The Bourtons Parish Council
Great & Little Bourton, Banbury, Oxfordshire

4 May 2022

Re : Planning application 21/00922/OUT : Land West of Foxden Way, Great Bourton

### Location Plan

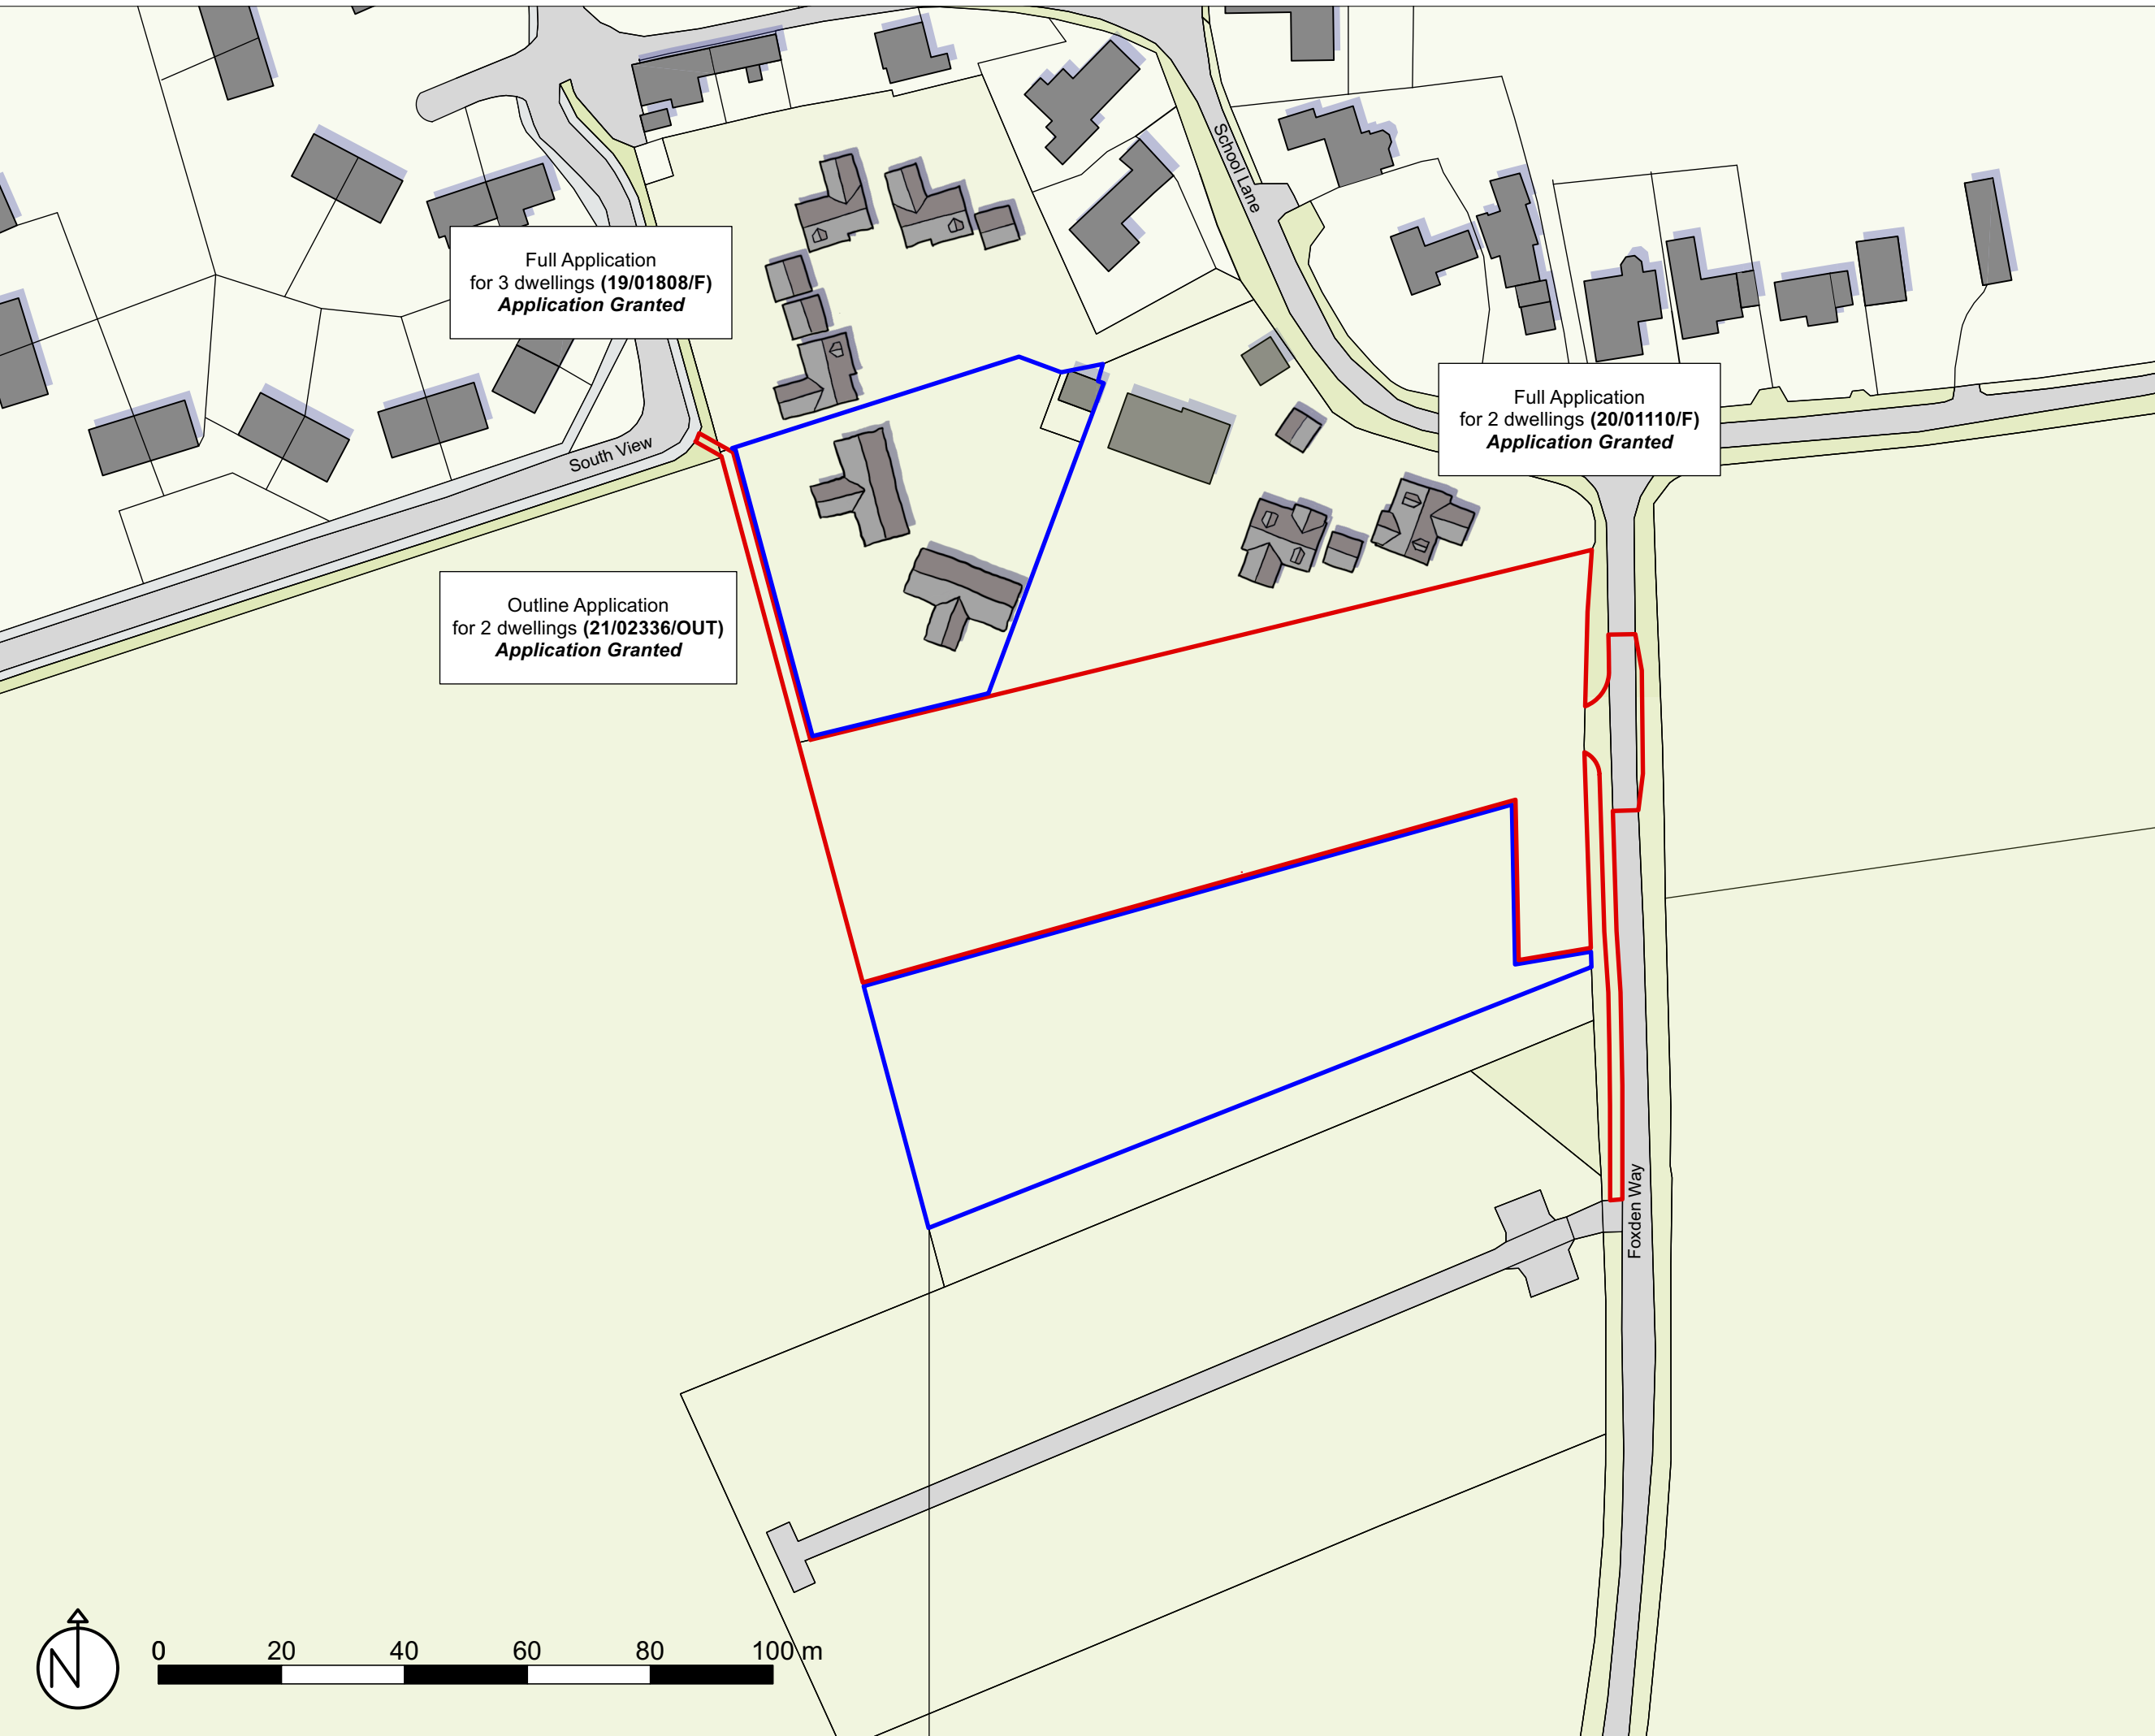
2.3 The parcel of land in question is adjacent to a greenfield space which was deliberately considered and chosen when we re-sited the Bourtons Allotments in 2017: we were assured at the time by CDC that the allotments would not be regarded as the boundary of the settlement. Furthermore, the submitted plan bears no relationship to the existing settlement other than the

addition of a footpath for which the proposed usage is unconvincing at best. For residents on this site who would choose to walk to local amenities in Cropredy, would no doubt use Crow Lane to access the footway – it is highly unlikely that they would walk initially in the opposite direction to walk to Cropredy via South View and the length of Main Street to access the footway.

2.4 The footpath would be of no use to the majority of the allotments holders who live either in Little Bourton or the eastern part of Great Bourton to access the allotments. In fact it would be useful only to one allotment holder who lives in South View and who most often currently drives to the allotments.

2.5 No doubt this footway was added to demonstrate that the site would have a connection to the existing settlement as required by such a development but we would suggest that it serves little or no useful purpose to existing or future residents.

TITLE
PROPOSED SITE ACCESS JUNCTION WITH VISIBILITY SPLAYS

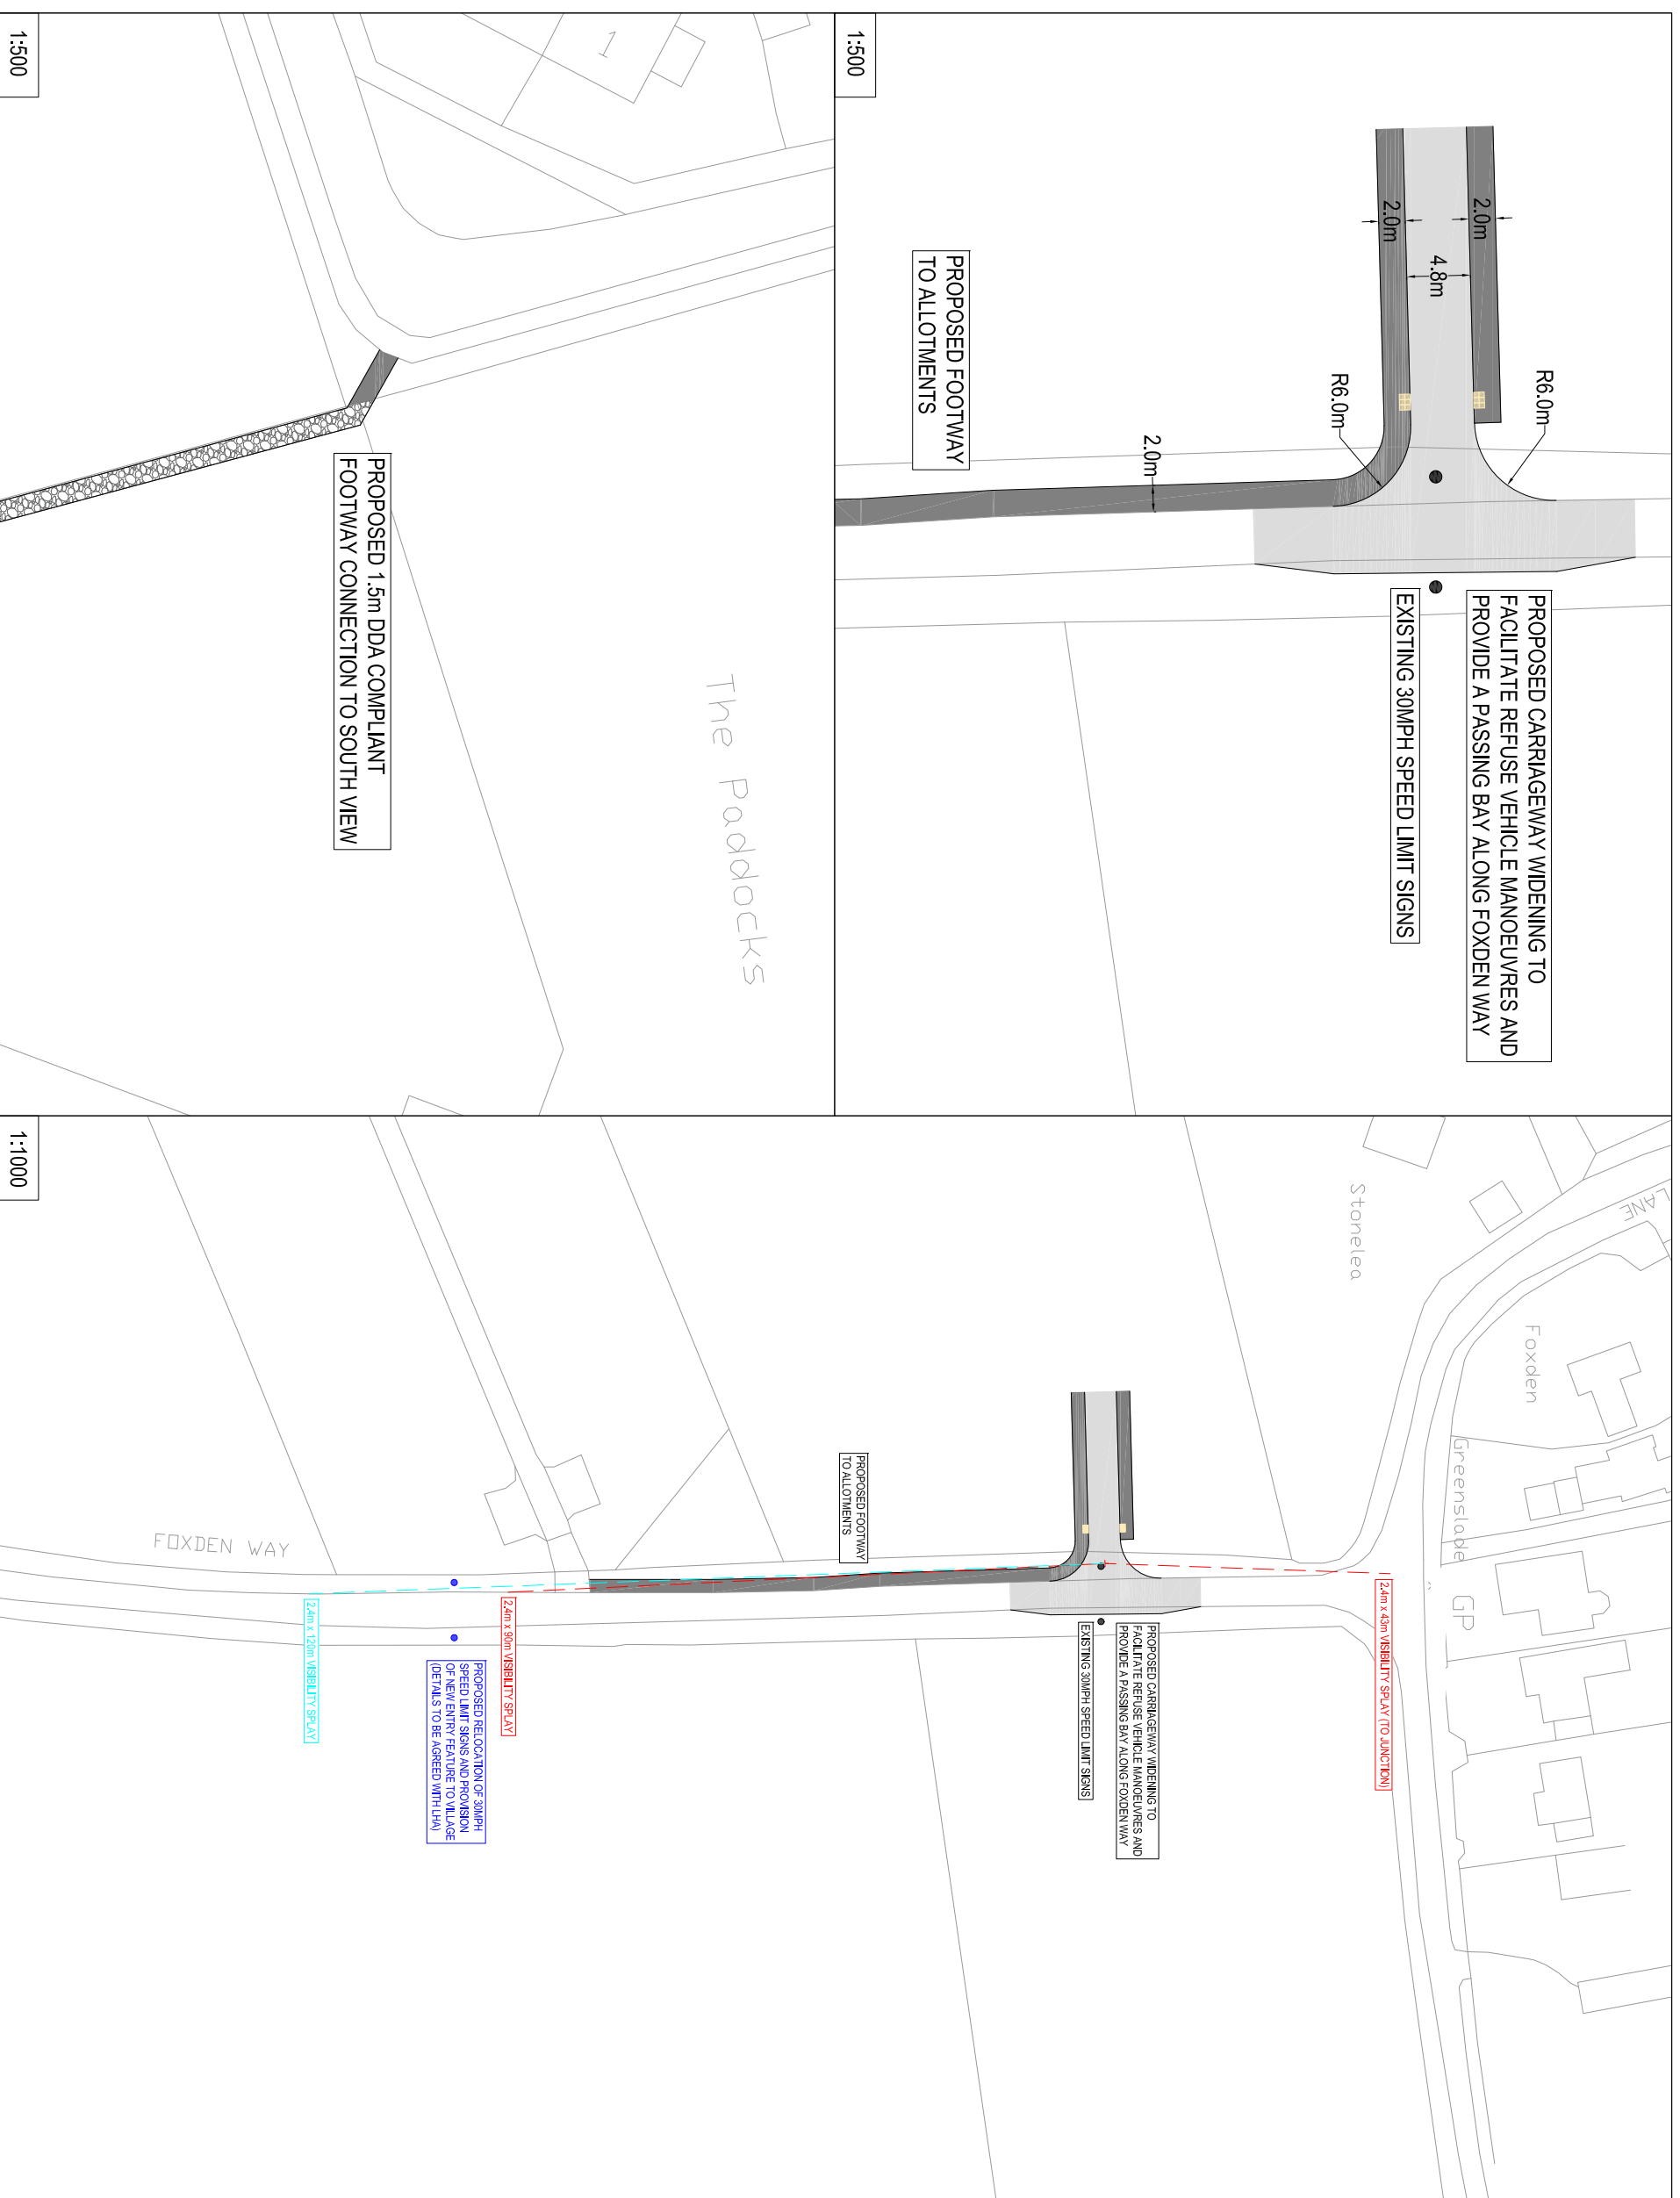
1.2.1 The applicants' statement in 2.7 and 5.12 of report T21512, describes Foxden Way as a lightly trafficked rural Lane that essentially operates as a 'quiet lane': **this is untrue.**

1.2.2 All roads to and from Foxden Way are single track roads and to suggest that residents' driveways in School Lane can be used for informal passing points is unacceptable.

1.2.3 Crow Lane is equally difficult for vehicles to pass each other and only a noticeably short stretch of it can accommodate passing vehicles. Furthermore the entrance to it from Main Street is particularly narrow, making it totally unsuitable for incoming construction traffic.
